REFERENCE : 21/01505/F and 21/01476/LB
Stone Hill House, Stone Hill, Bloxham OX15 4PT

We write to strongly object to the revised plans submitted for the above applications.

PROPOSED SOUTH ELEVATION
1: 100 @ A1

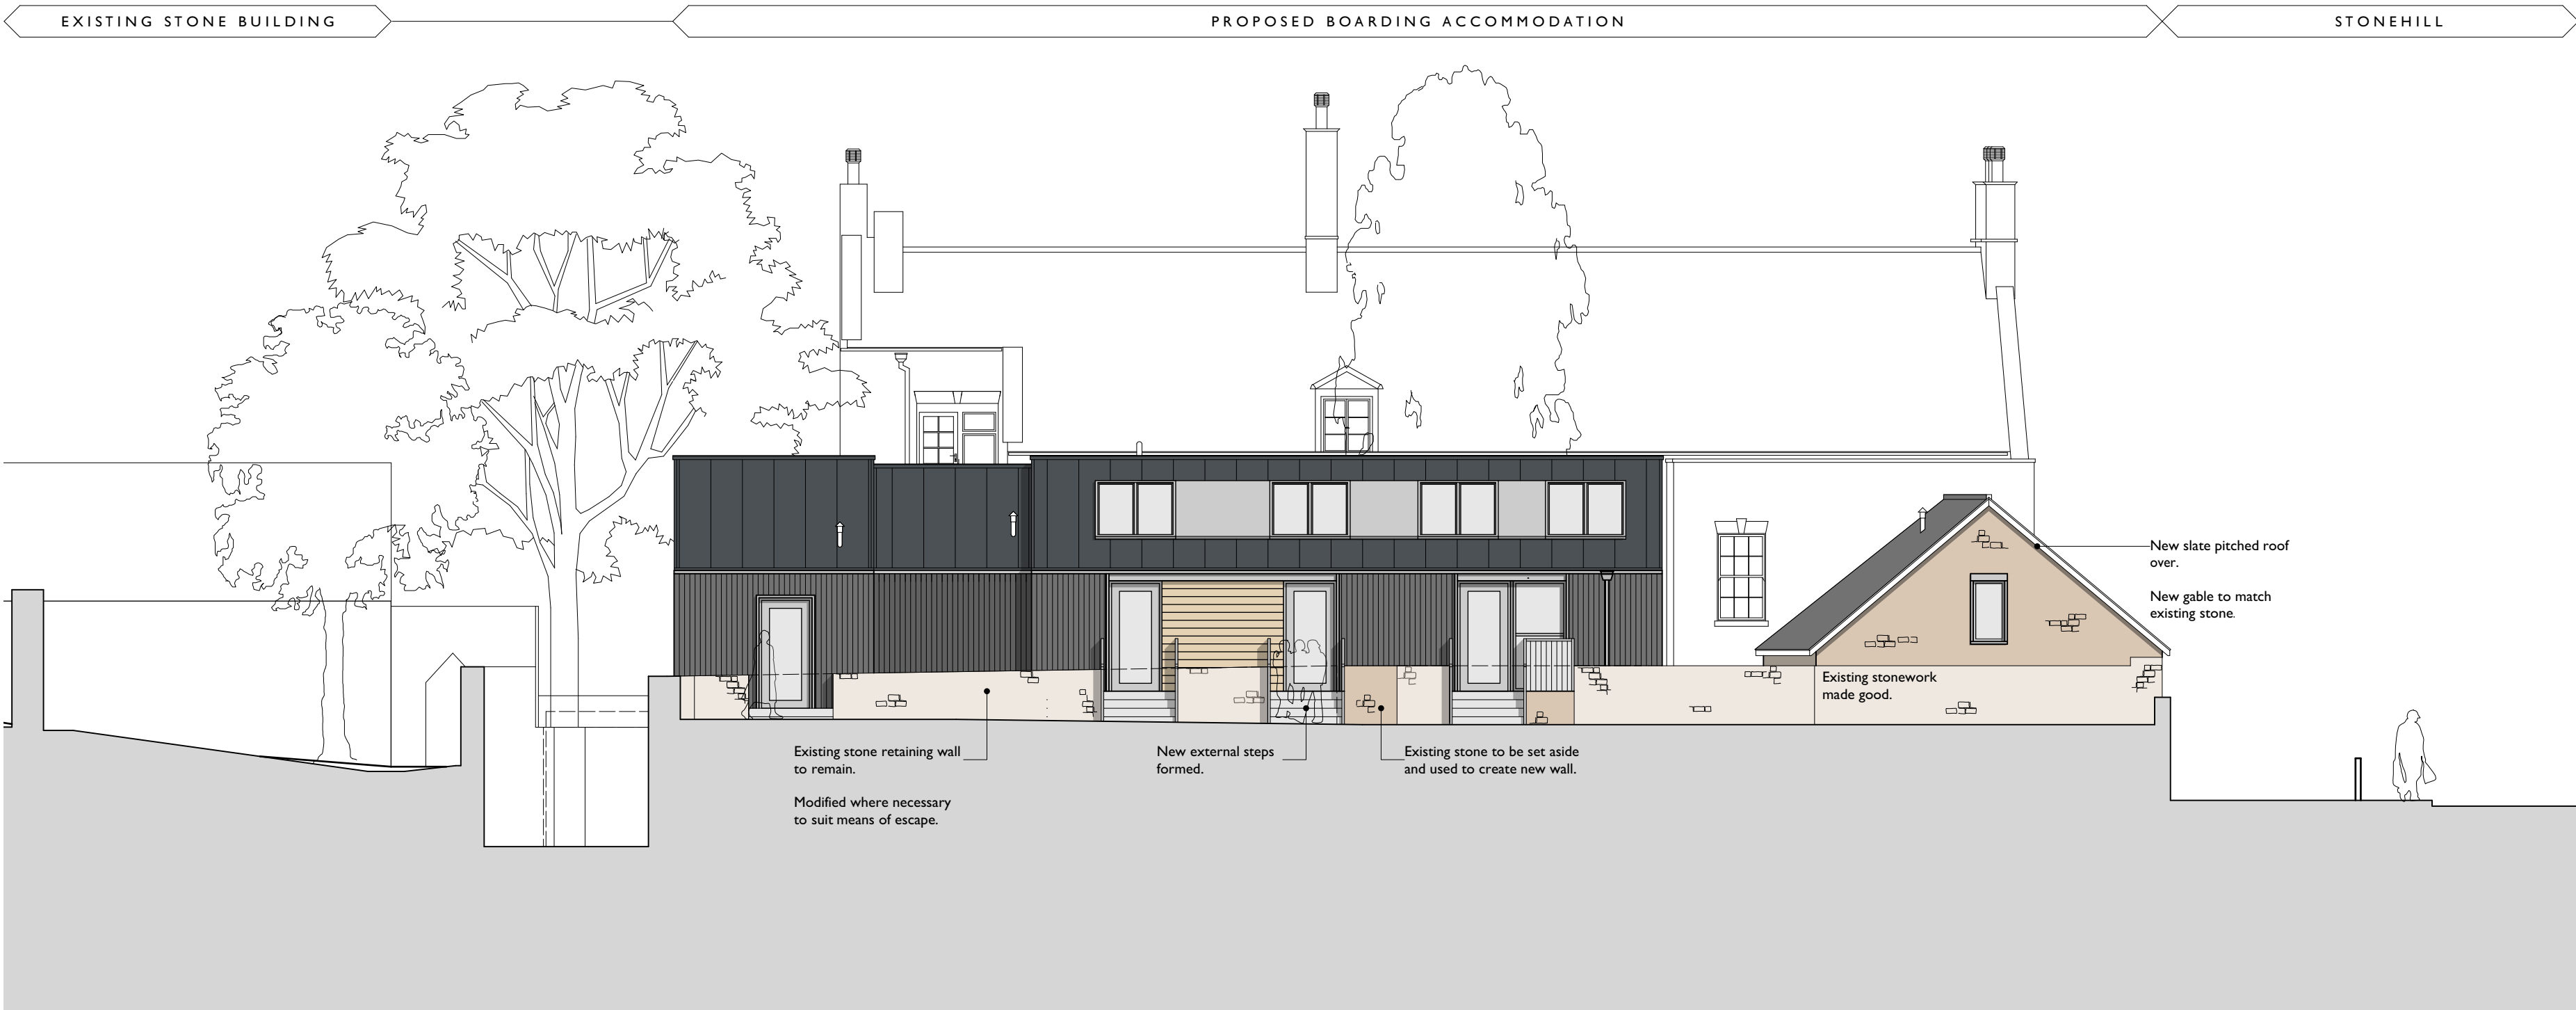
3. The main building materials presented in the plans are not in keeping with the conservation area – the structures are mostly black with sheet roofing, wooden clad in areas and with an array of windows - blatantly modern, boldly unattractive and incongruous with its’ surroundings which are heritage/listed buildings built predominantly with ironstone and slate roofing. **BNP Item BL11.**

5. Within the drawings, the insertion of doors and glazed panels facing the lane are not acceptable and are completely abstract to the current historic appearance of Stone Hill. The drawings also clearly show these apertures opening outwards across the pavement to the detriment of pedestrians (and/or parked vehicles).
